Our Reference: SYD17/01262 (A19215293)  
DP&E Ref: SSD 8200

**PROPOSED RESOURCE RECOVERY FACILITY - 21 AND 25 DUNHEVED CIRCUIT, ST MARYS**

Reference is made to the Department of Planning and Environment (DP&E) letter dated 11 September 2017, regarding the abovementioned application which was referred to Roads and Maritime Services (Roads and Maritime) for comment.

REV.	DESCRIPTION	DRAWN	CHECK	APP'D	DATE
A	ISSUE FOR DISCUSSION	LM	SB	SB	15/06/17

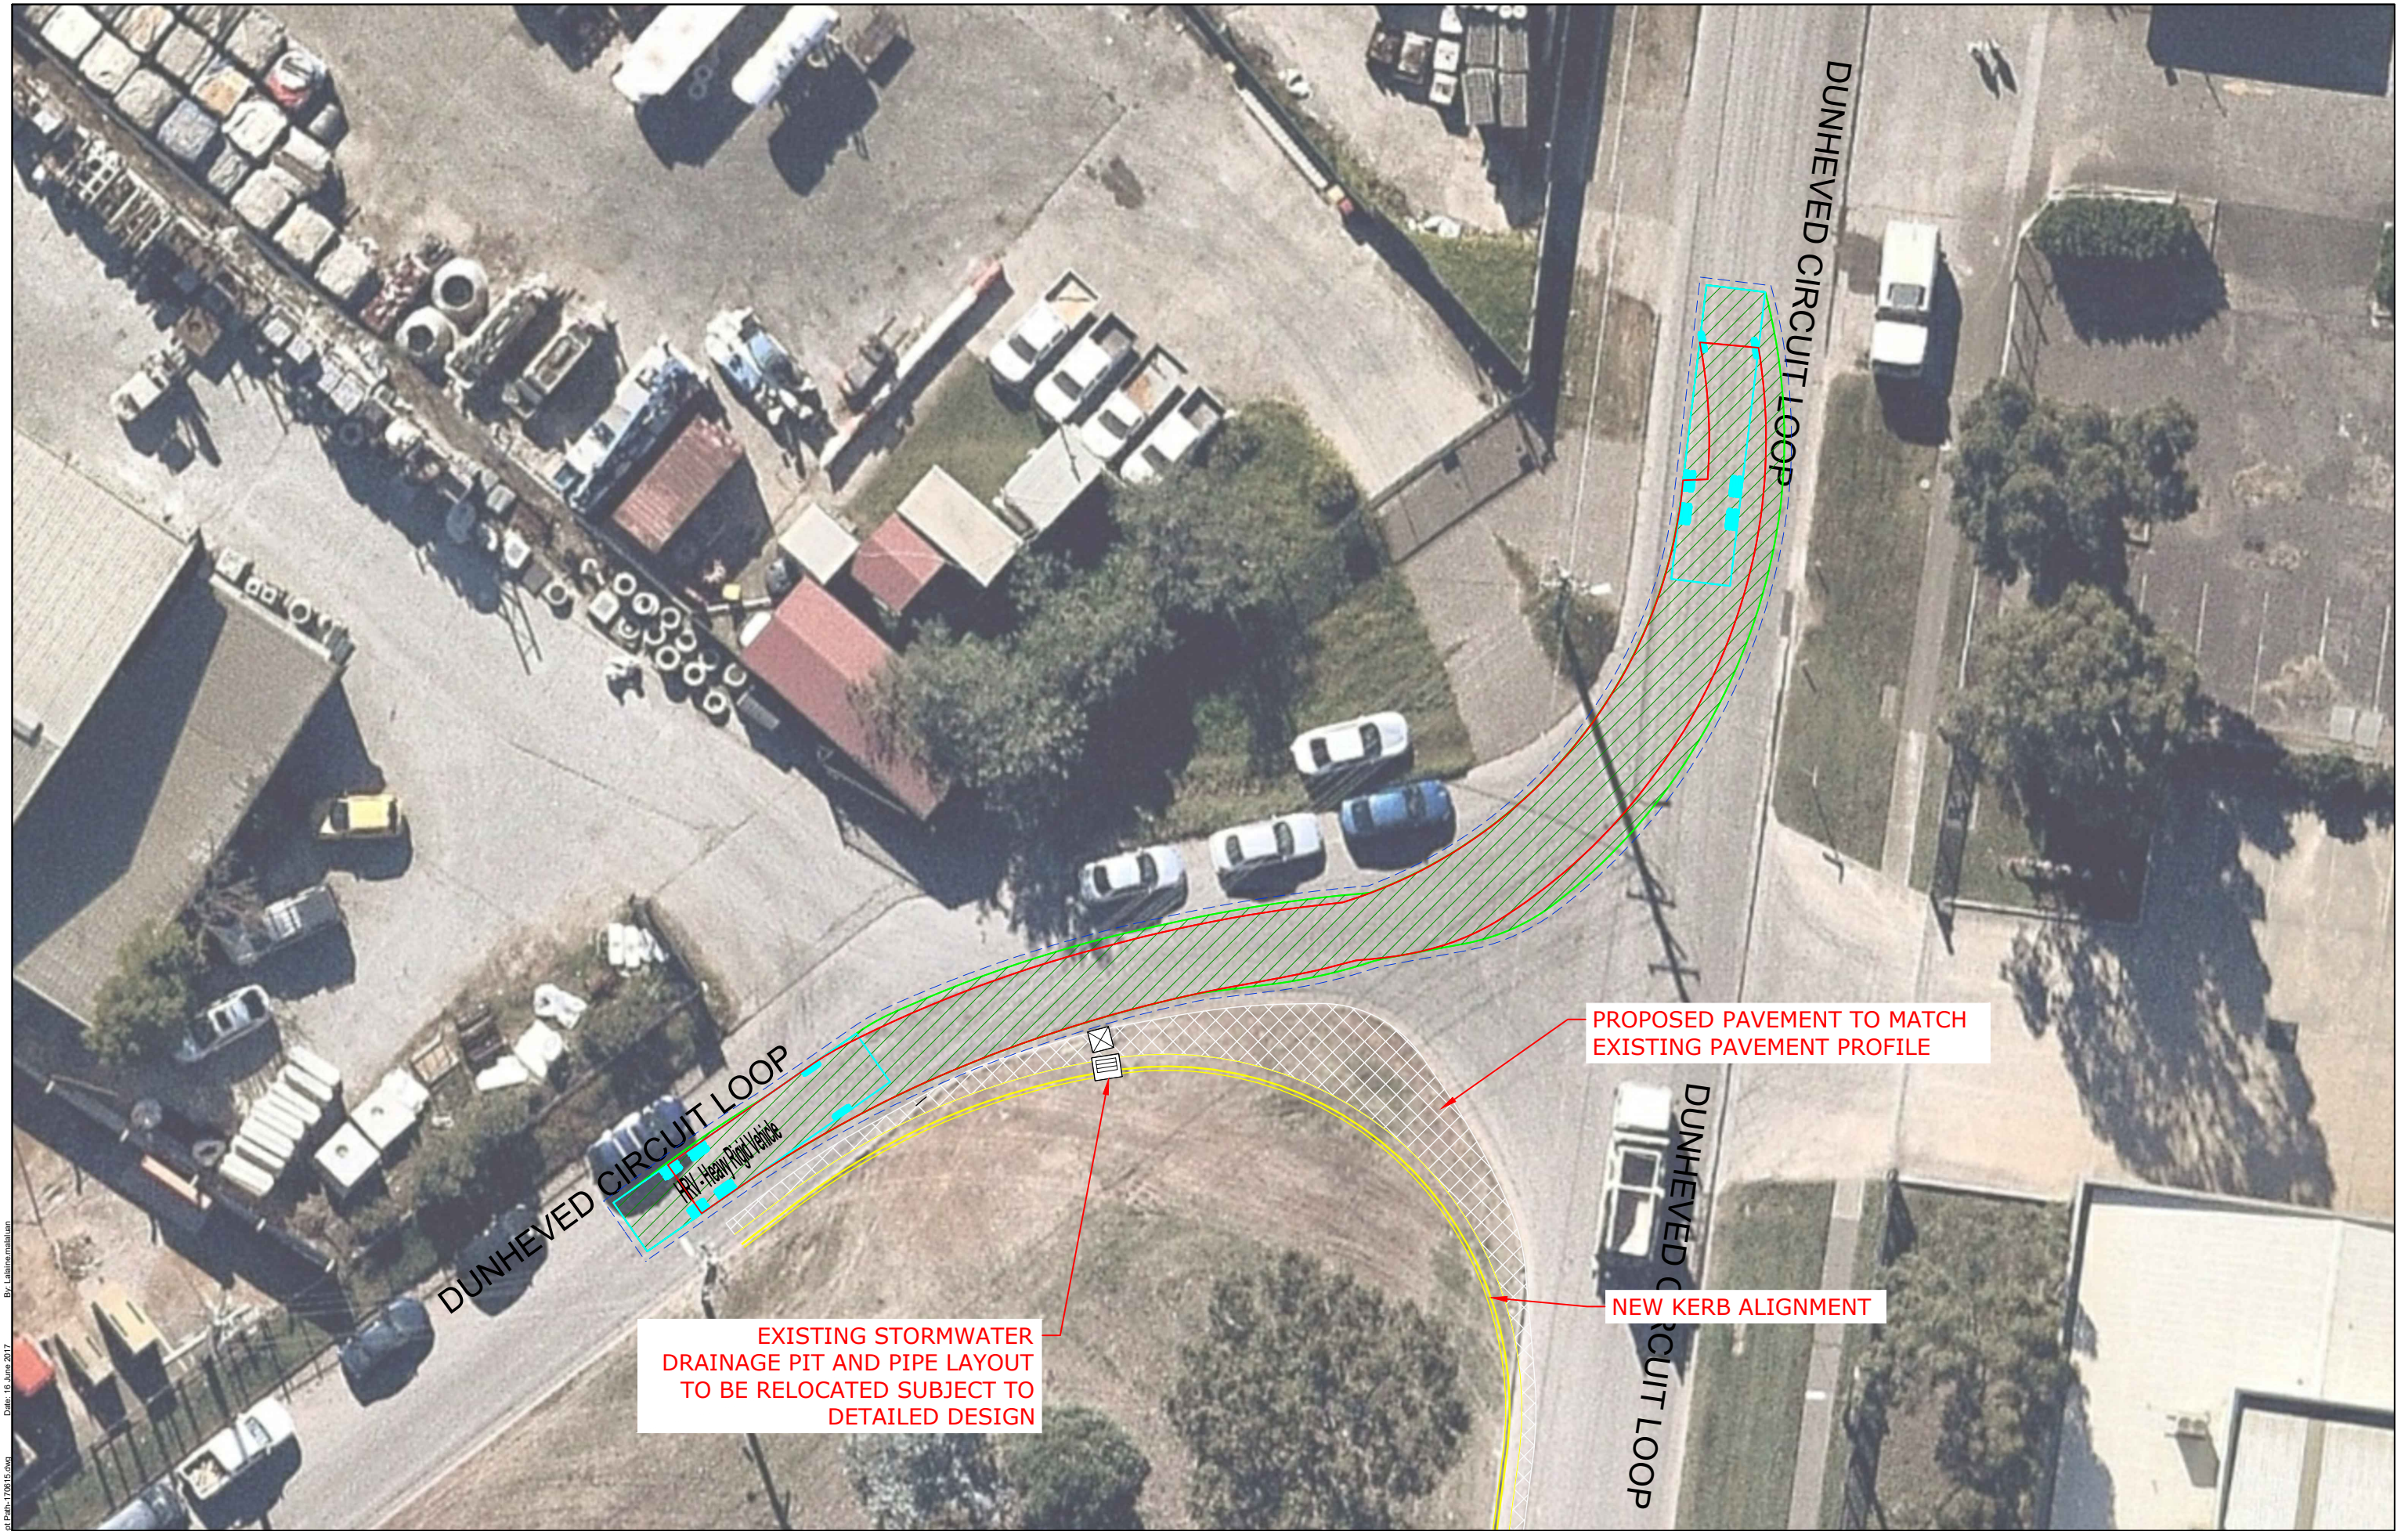
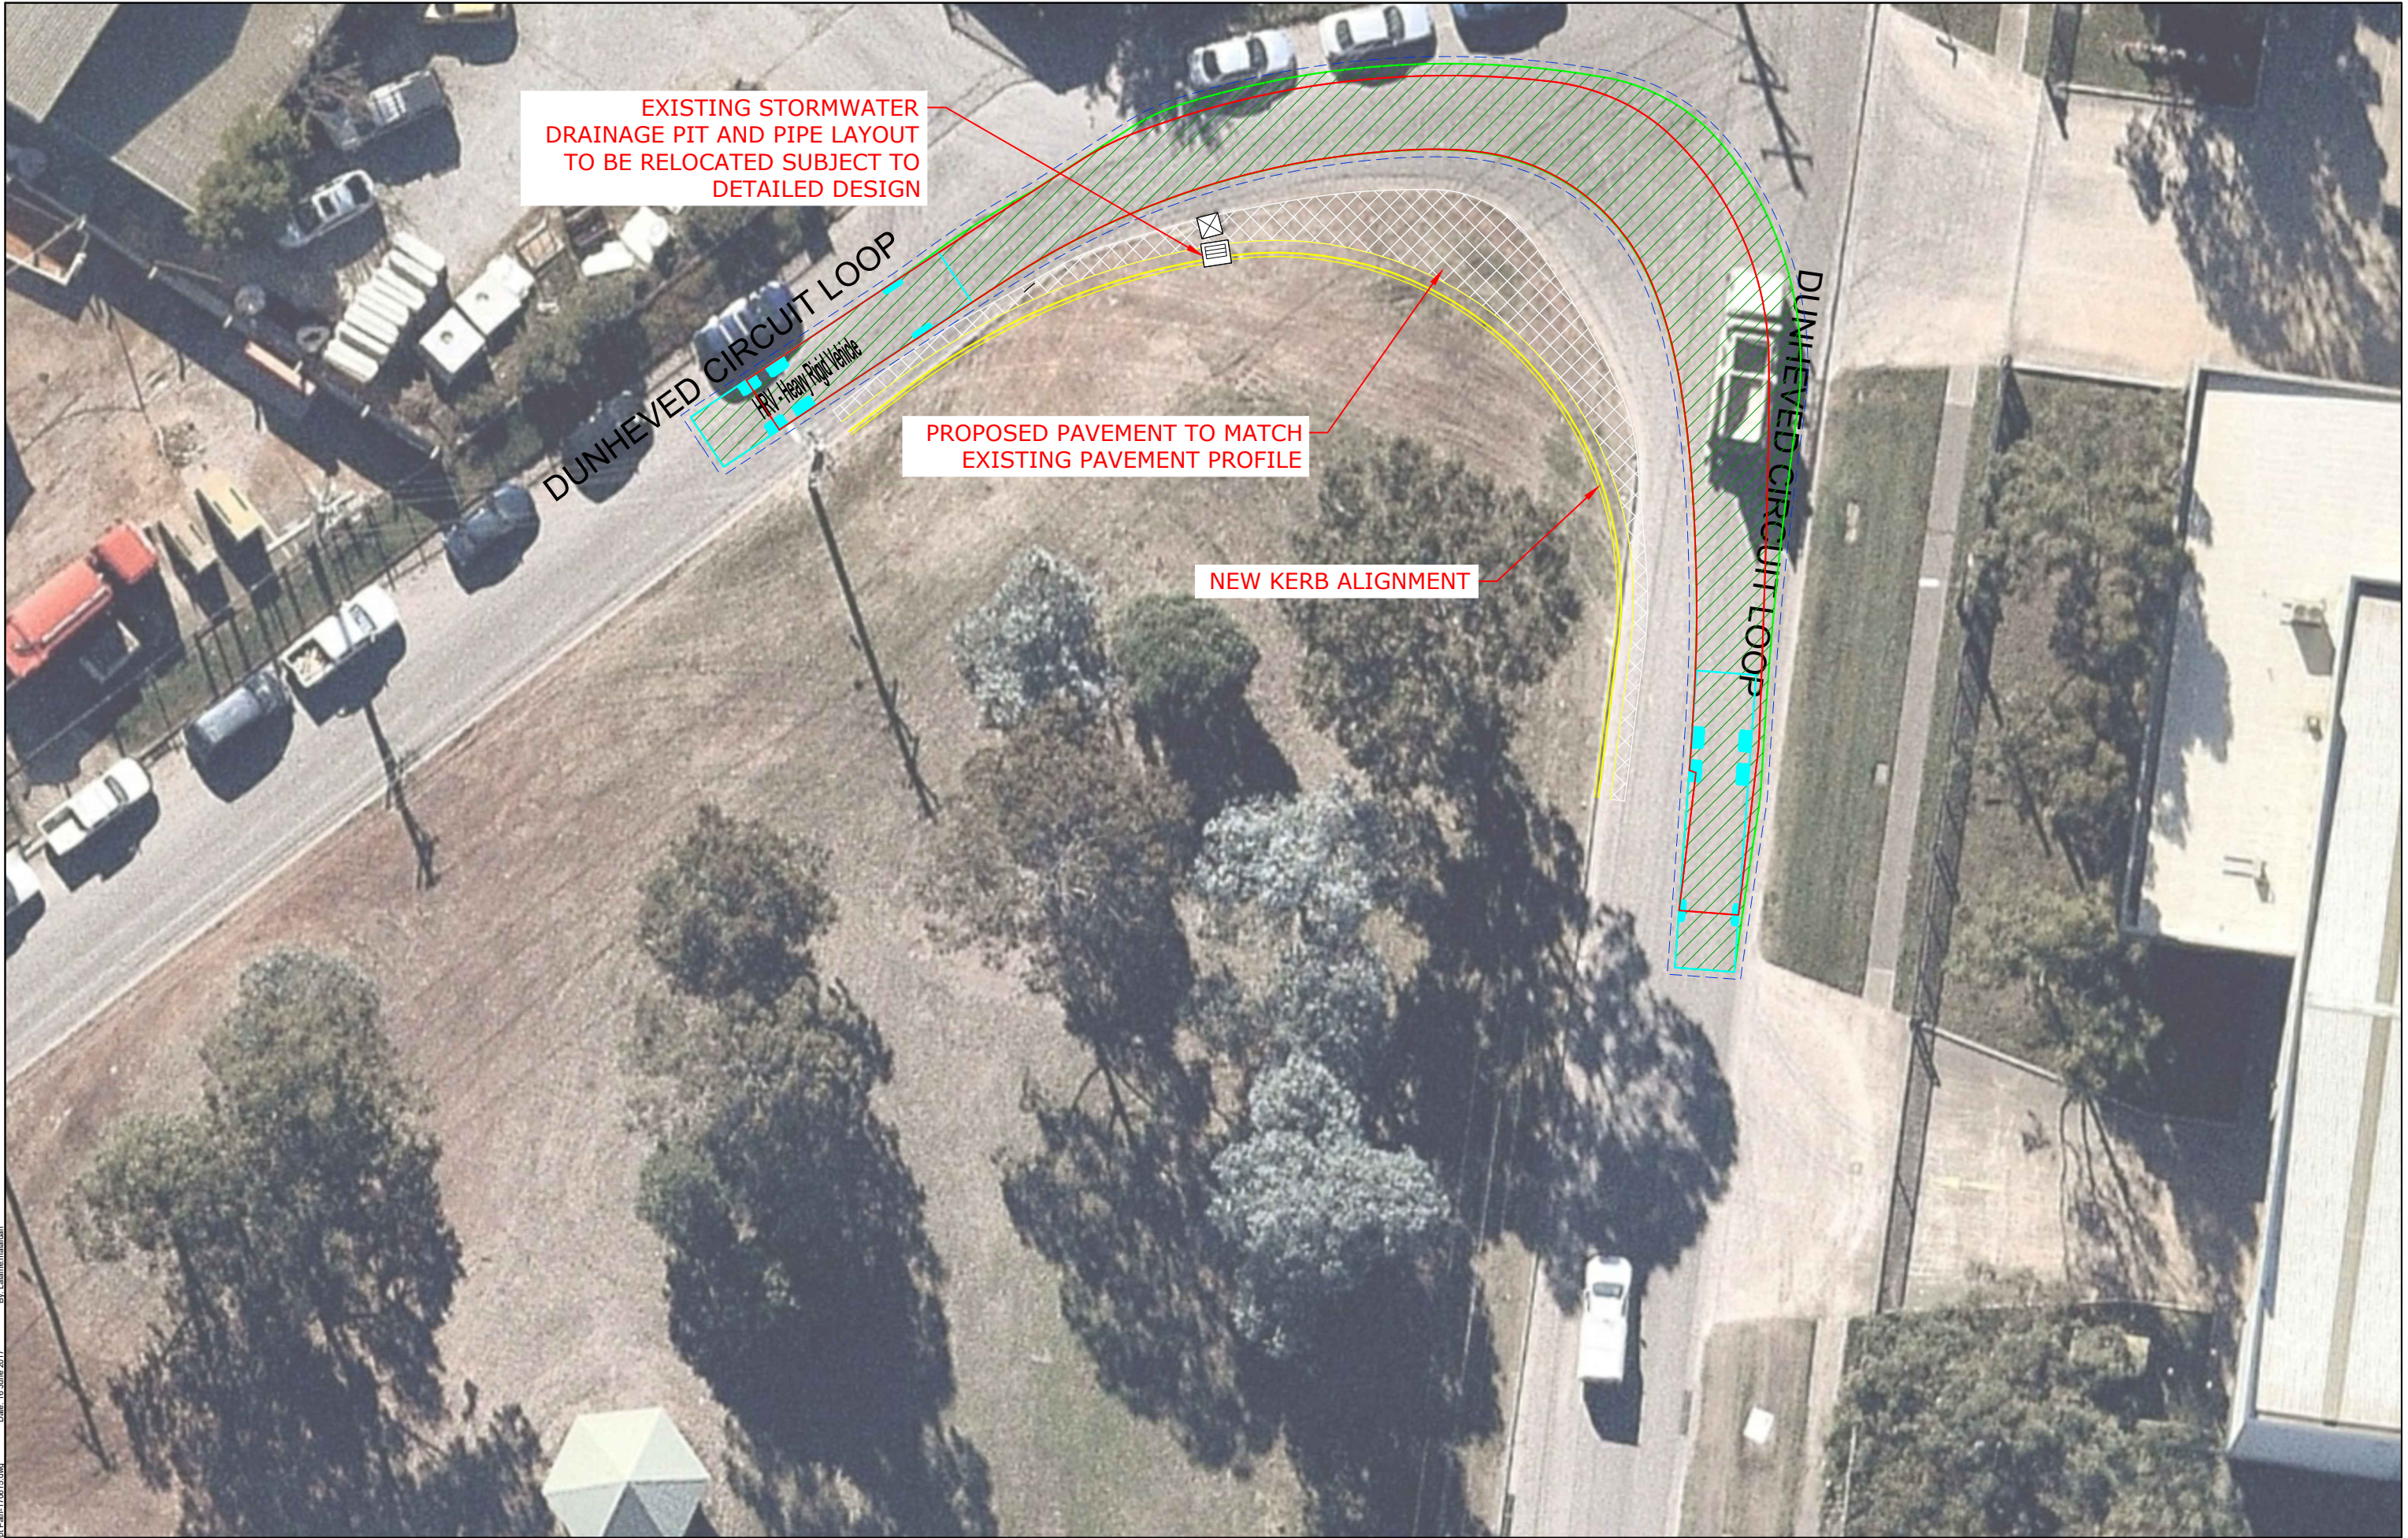
3. The swept path of the longest vehicle entering and exiting the subject site, as well as manoeuvrability through the site, shall be in accordance with AUSTROADS. In this regard, a plan shall be submitted to Council for approval which shows that the proposed development complies with this requirement.
